City of Portland, Maine - Building or Use Permit Application
 389 Congress Street, 04101 Tel: (207) 874-8703, Fax: (207) 874-8716

PERMIT ISSUED	
Permit No: 02-0819	CBL: 352 A050001
AUG 2 2002

Location of Construction: 18 Dole Dr	Owner Name: Reardon Monica	Owner Address: 18 Dole Dr	Phone: 797-2354
Business Name:	Contractor Name: Solution Builders	Contractor Address: 32 Hamlin Rd Falmouth	Phone: 2077978242
Lessee/Buyer's Name	Phone:	Permit Type: Additions - Dwellings	Zone: R-2
Past Use: Single Family	Proposed Use: Single Family	Permit Fee: \$422.00	Cost of Work: \$57,000.00
Proposed Project Description: Construct 24' X 24' Garage Addition/Attached with a 10' x 10' Breezeway		FIRE DEPT: <input type="checkbox"/> Approved <input type="checkbox"/> Denied N/A	INSPECTION: Use Group: R-3 Type: 5B BOLA 99 YH
		PEDESTRIAN ACTIVITIES DISTRICT (P.A.D.) Action: <input type="checkbox"/> Approved <input type="checkbox"/> Approved w/Conditions <input type="checkbox"/> Denied Signature: N/A Date:

This is to certify that Reardon Monica/Solution Builders
has permission to Construct 24' X 24' Garage Addition/Attached with 10' x 10' breezeway
AT 18 Dole Dr City of Portland 352 A050001

SITE PLAN Dole Drive Portland, Maine for Bob Martin P.O. Box 545 Mechanic Falls, Me. 04266	
BRUCE R. BOWMAN, Inc. Professional Land Surveyor Box 12A Cumberland, Maine (207) 829-3959 (Fax) 829-3522	
Date: 7-7-97	Job: 97016
Drawn By:	Scale: 1"=20'

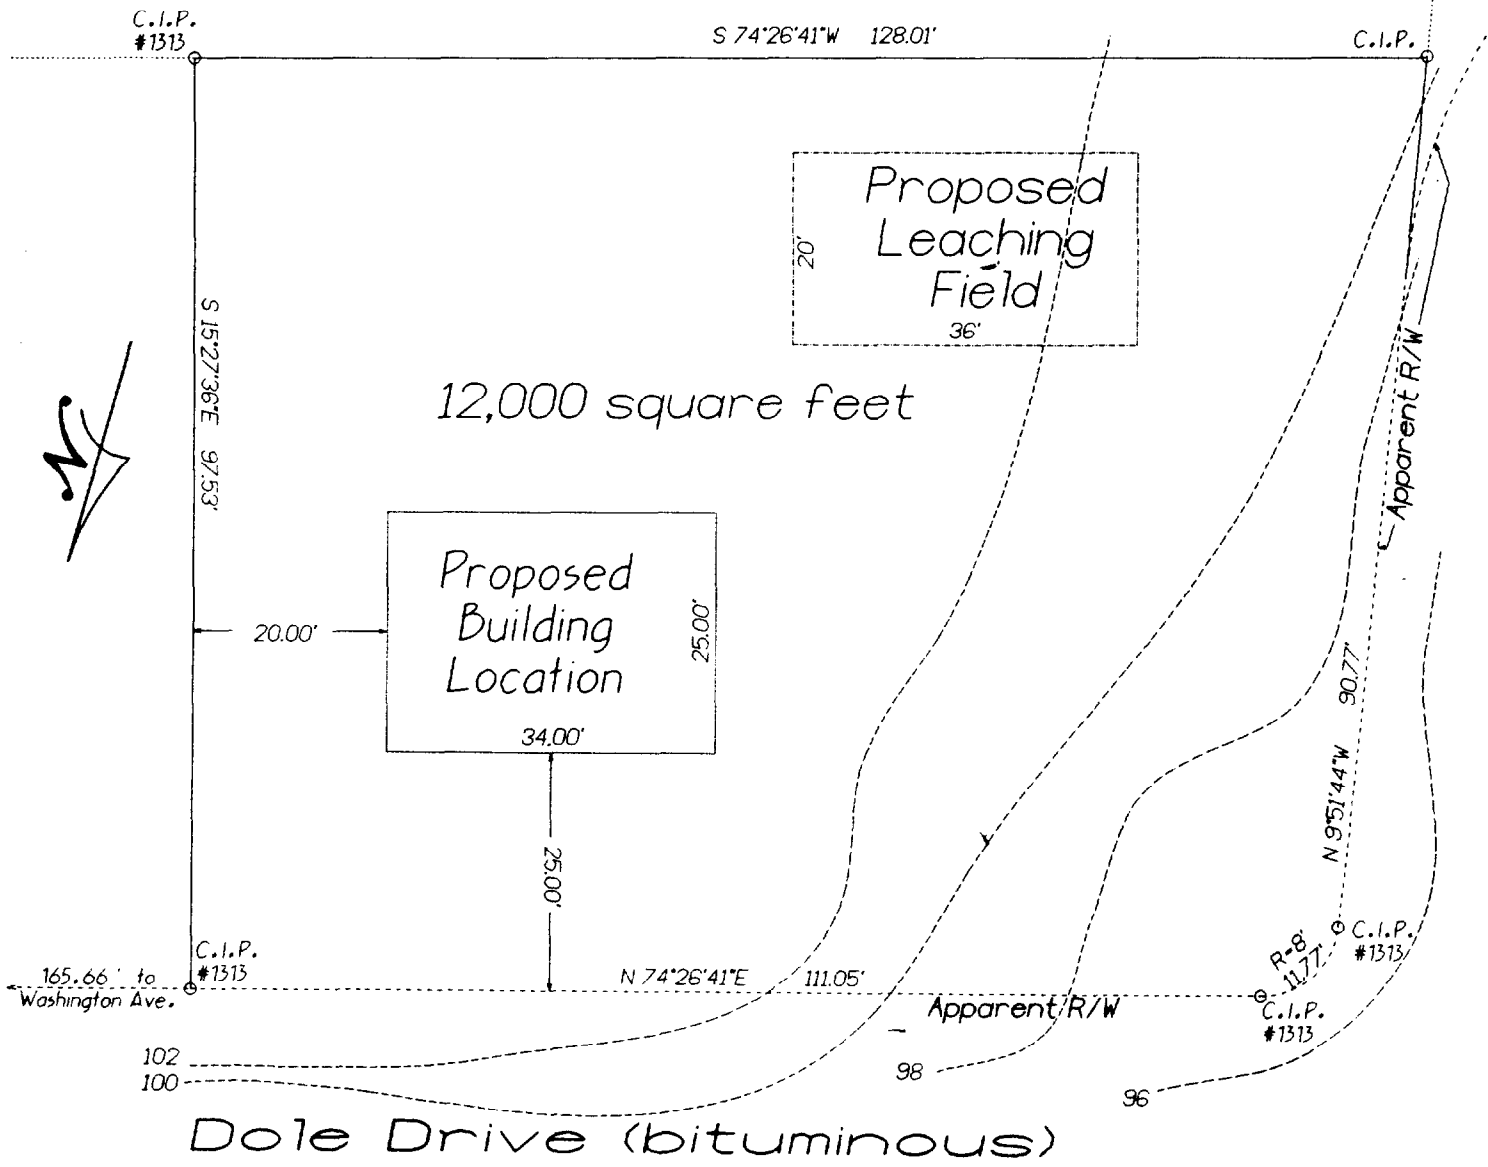
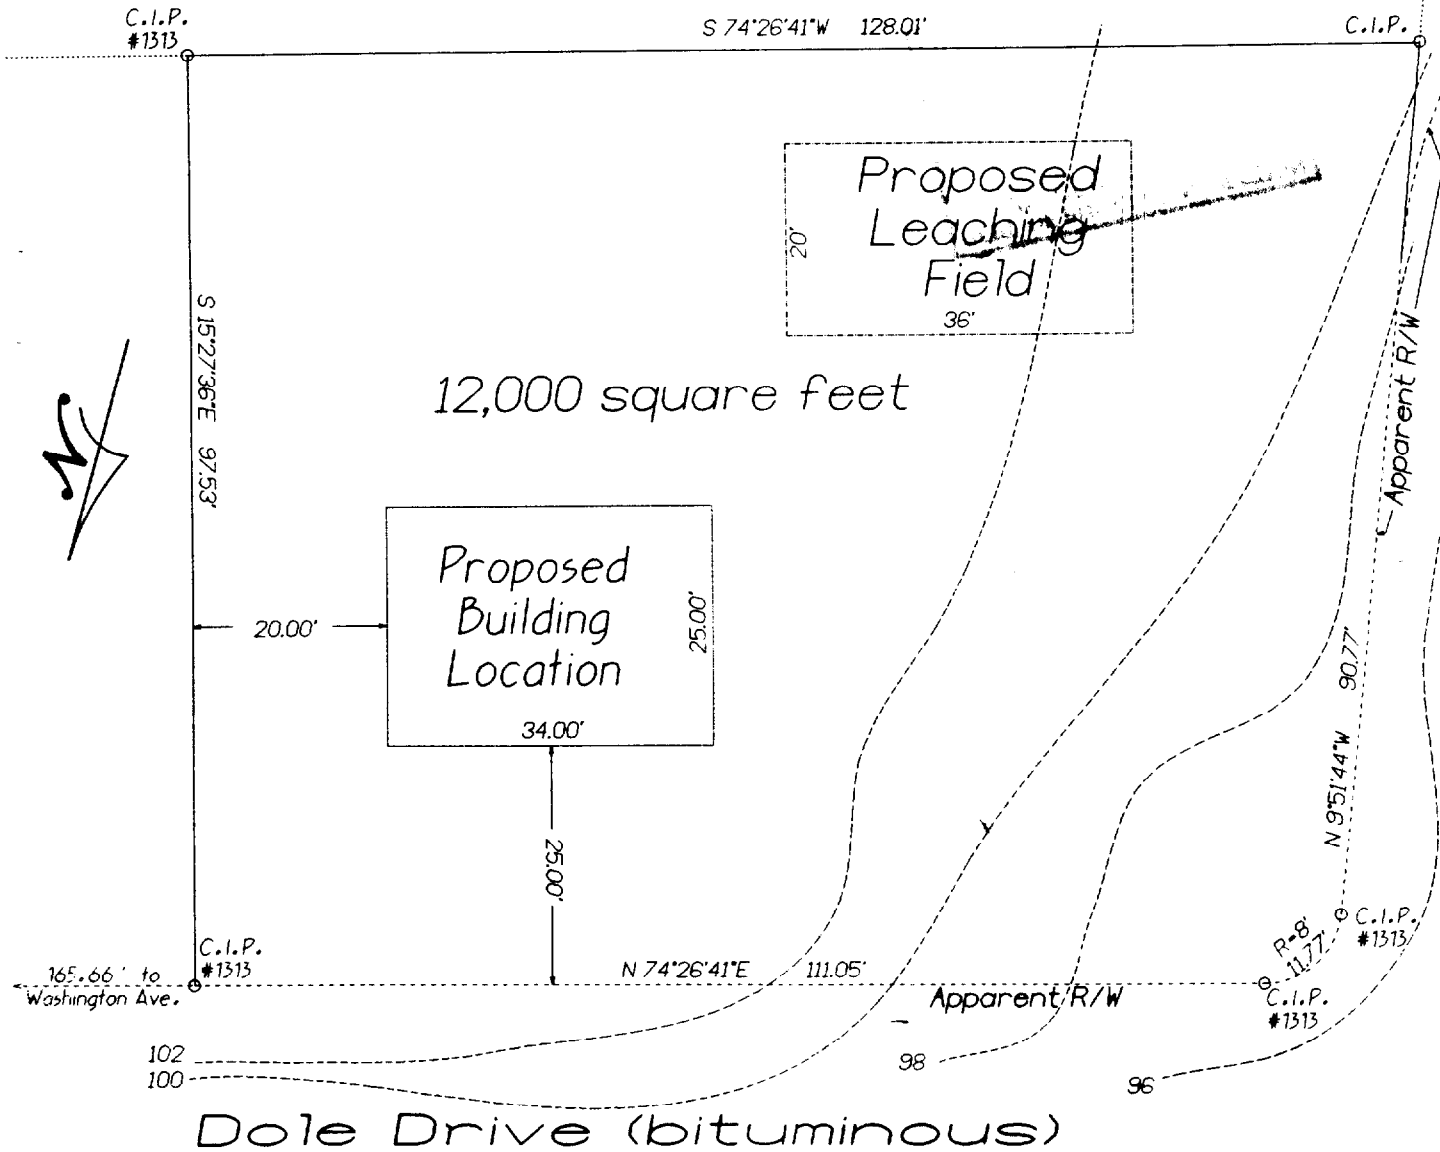
Comments: 18 Dole Dr. - 7/29/02 - There is a problem with the front setbacks. The setbacks and building size does not add up correctly. I requested that the contractor give us accurate plans to reflect what actually is. 25 ft is required for a front setback. Permit is on hold until plans received.

It has been noted that your single family dwelling does not have the required 25 foot front setback as required in the R-3 zone. A survey received by this office show 17'8" instead. If this setback is not legalized in some manner, the future sale of your home maybe in jeopardy. Please contact this office immediately to learn your options to correct this violation.

Joe,
I am still questioning your front setback measurements to the property lines (not street lines) - I don't think 36' is accurate because the survey says there is only 17.8' to the front ~~prop~~ property line from the existing house. No less than

25 feet is required - Please Amend your plans appropriately to property line setbacks - Marge
